SF2011/001291
MJ

Infrastructure Projects
NSW Department of Planning and Infrastructure
GPO Box 39
SYDNEY NSW 2001

**NEW ENGLAND HIGHWAY (HW9): ADEQUACY OF ENVIRONMENTAL ASSESSMENT FOR
HEXHAM RELIEF ROADS (RAIL PROJECT), TARRO (SSI-4992)**

I refer to your letter dated 7 August 2012 requesting comment from Roads and Maritime Services (RMS) regarding the adequacy of the Environmental Assessment (EA) for the subject project.

Figure 6.1 Proposed sketch layout of Anderson Drive intersection with the temporary construction access road

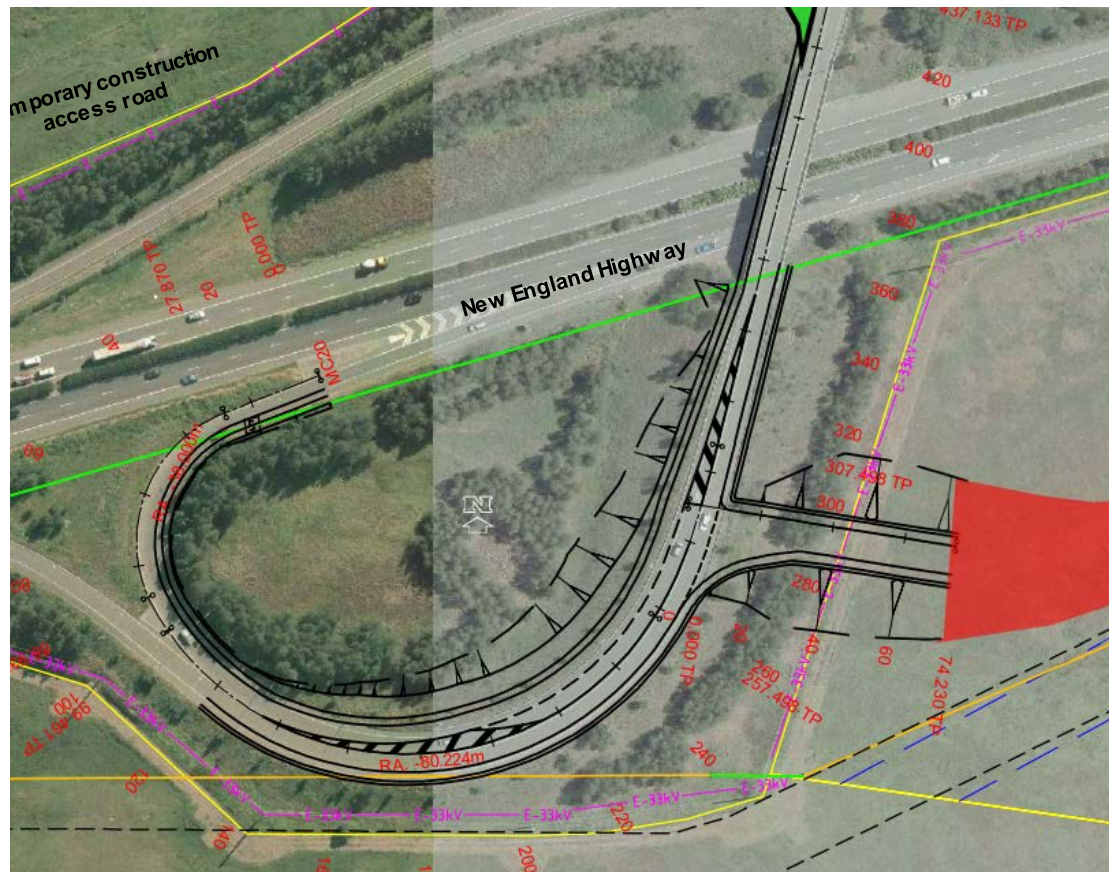
- Access to the Hexham Relief Roads worksite shall be via a new T intersection (Austroads Type CHR / CHL) to be designed and constructed by the proponent to RMS requirements on Anderson Drive (Tarro Interchange) on the southern side of the New England Highway (Attachment A). Vehicular access at this intersection shall be restricted to right in / left out for heavy vehicles. Right in / left out / left in movements shall be permitted for light vehicles.

- The proposed Hexham Relief Roads worksite access road connecting the new T intersection with the southern section of Woodlands Close shall be sealed and designed / constructed to Council requirements.

- Vehicular access to / from the Hexham Relief Roads worksite via Woodlands Close shall not be permitted on road safety grounds. All vehicular access shall be via the new Anderson Drive T intersection and Hexham Relief Roads worksite access road.

Comment: RMS would consider permitting temporary access via the New England Highway / Woodlands Close intersection to allow heavy machinery access for the construction of the proposed Anderson Drive T intersection and Hexham Relief Roads worksite access road until such time as access is possible via the Tarro Interchange. RMS will not permit haulage trucks and the construction workforce to access the Hexham Relief Roads worksite via the New England Highway / Woodlands Close intersection. The applicant must investigate other options for haulage vehicles and the construction workforce to access the worksite.
